Rezoning Transportation Analysis

Petition Number: 2019-180

| Date | Description |
|------------|-------------------------|
| 09-22-2020 | Fourth Review (LJensen) |

**RZ-2.0**

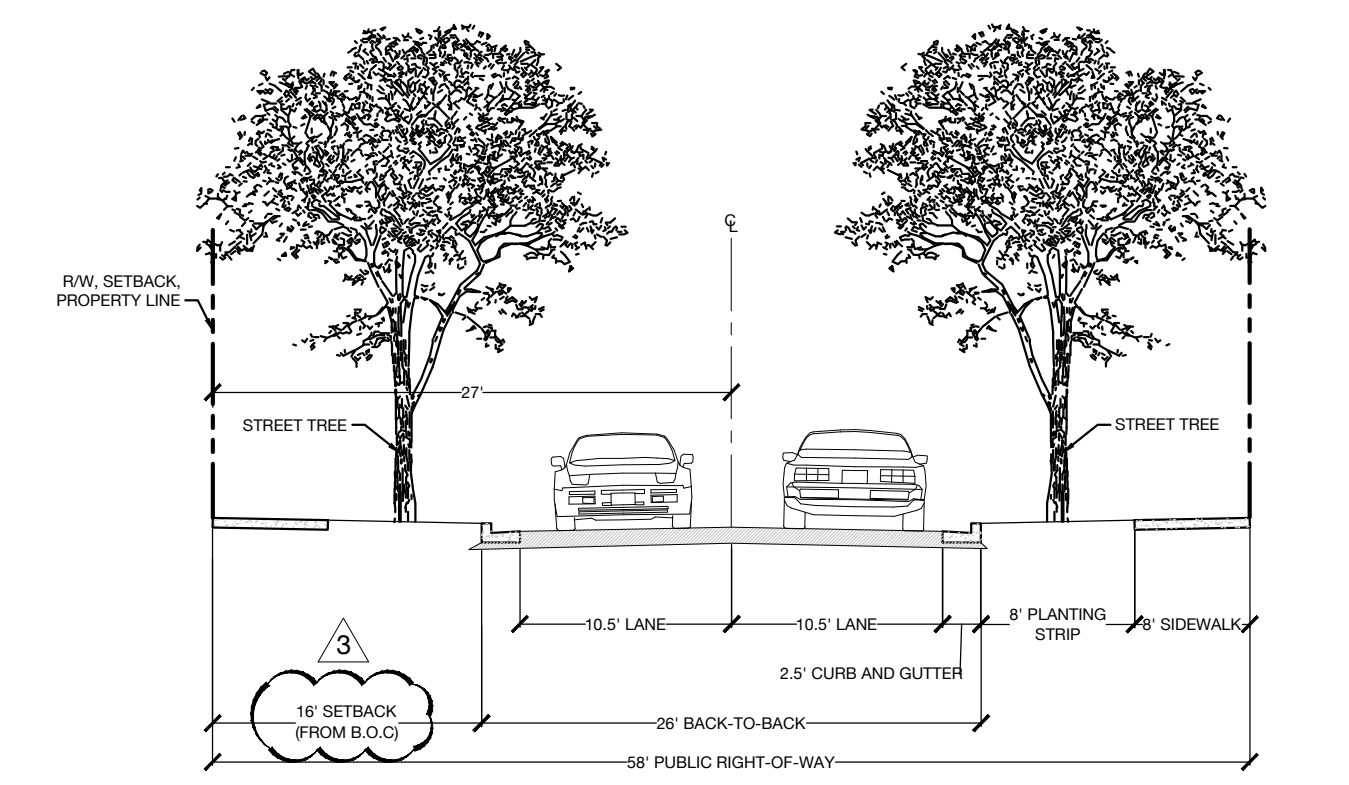
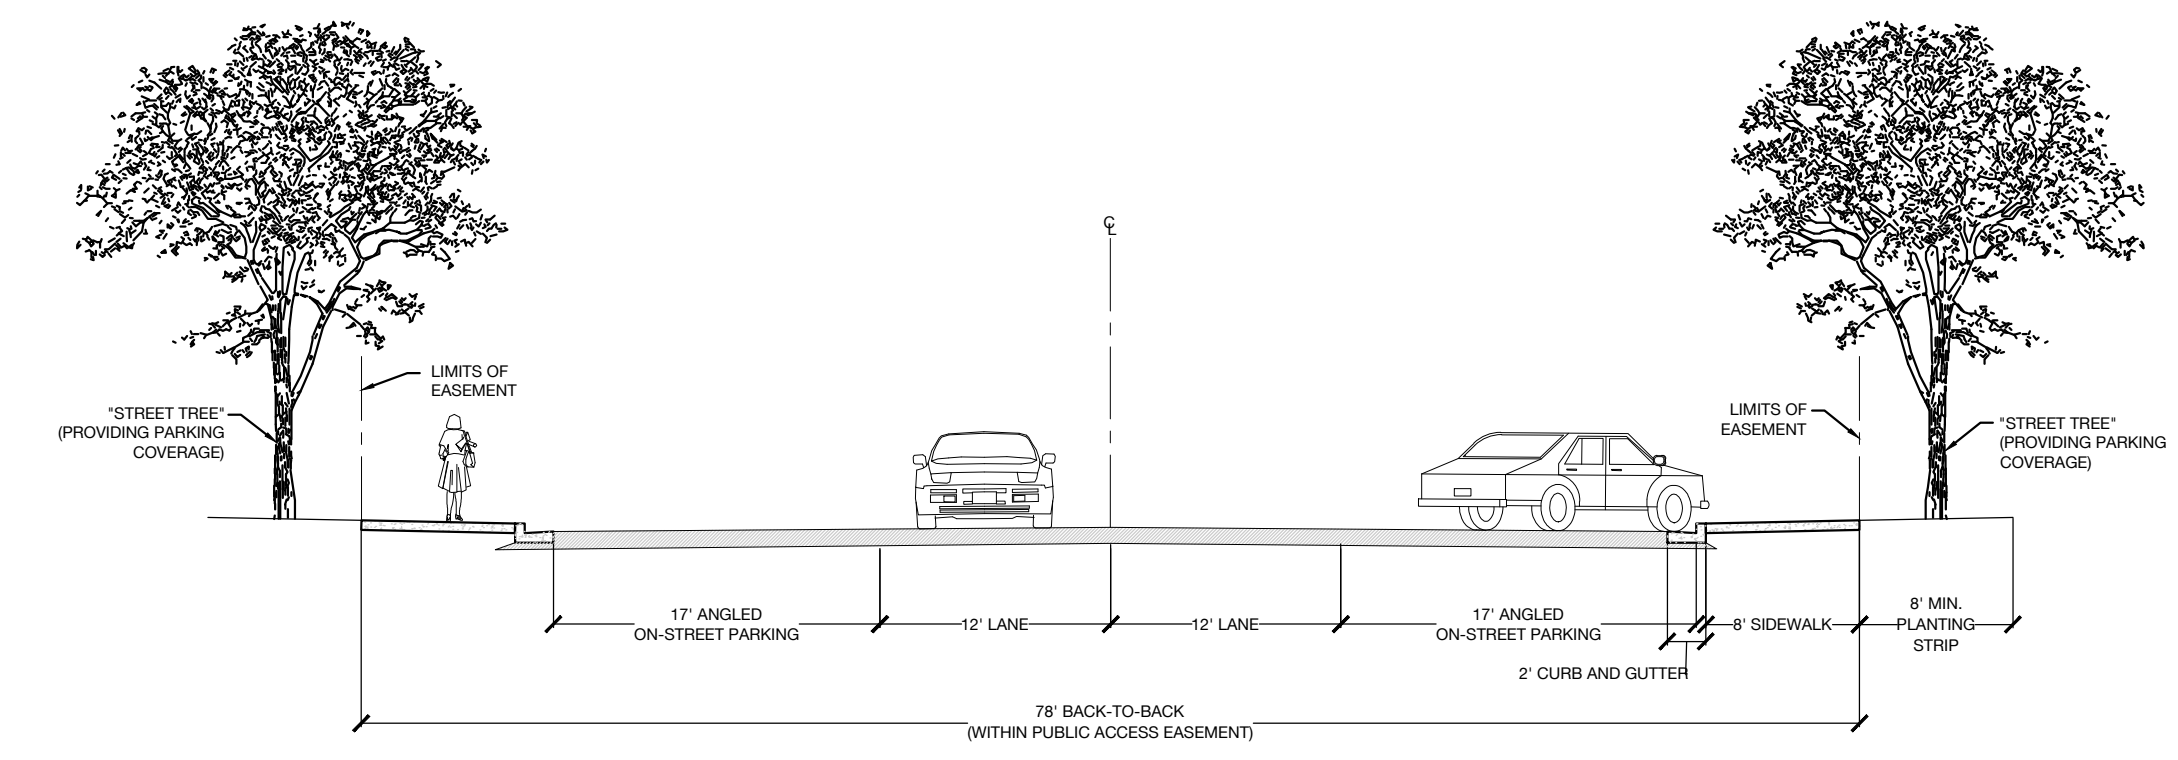
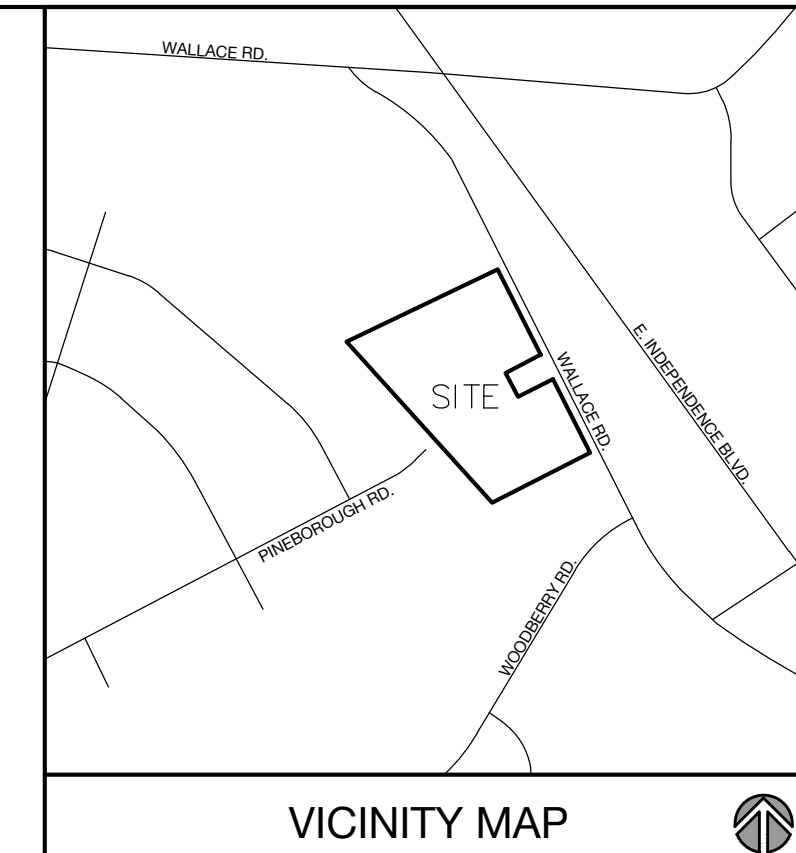
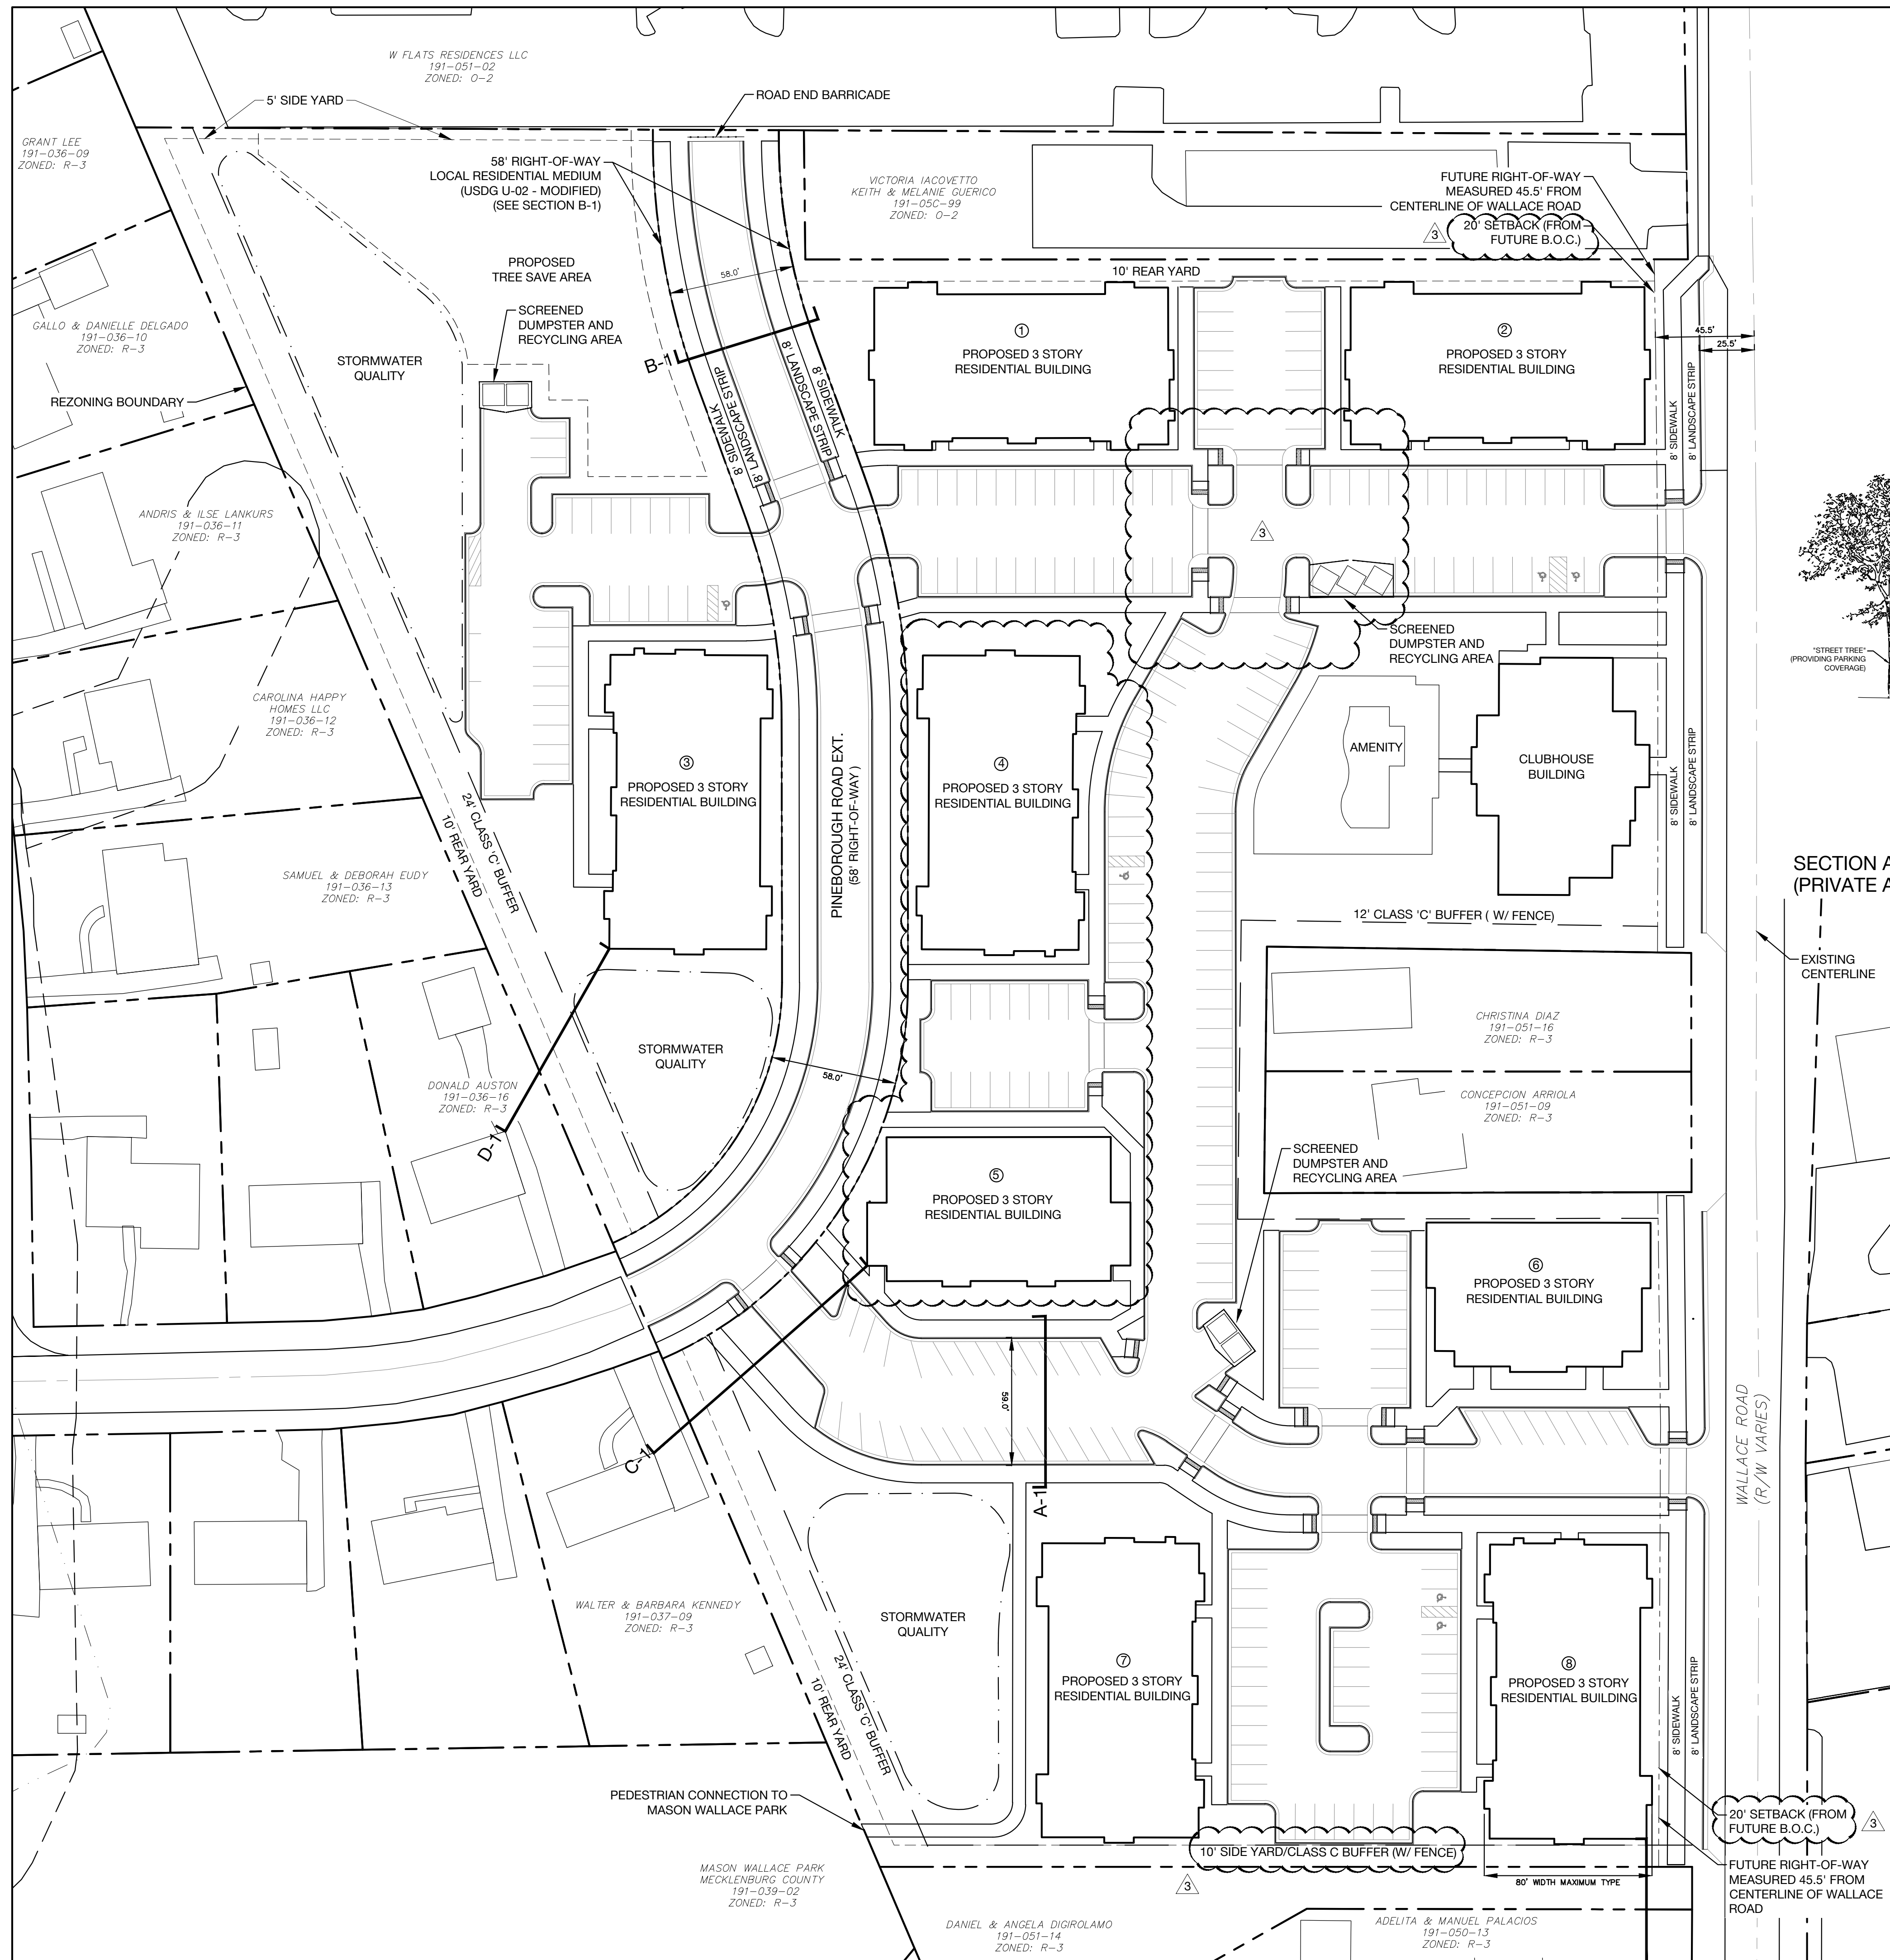
The site is located on Wallace Road, a minor thoroughfare, City-maintained road. The proposed land and intensity of 201 residential units will generate 1,095 daily vehicle trips. The proposed site plan needs to be revised to include noting dedication and conveyance of right-of-way and transportation improvements being completed prior to the issuance of the first certificate of occupancy.

The site plan should show the curb and gutter labeled and dimensioned from the centerline for each road.
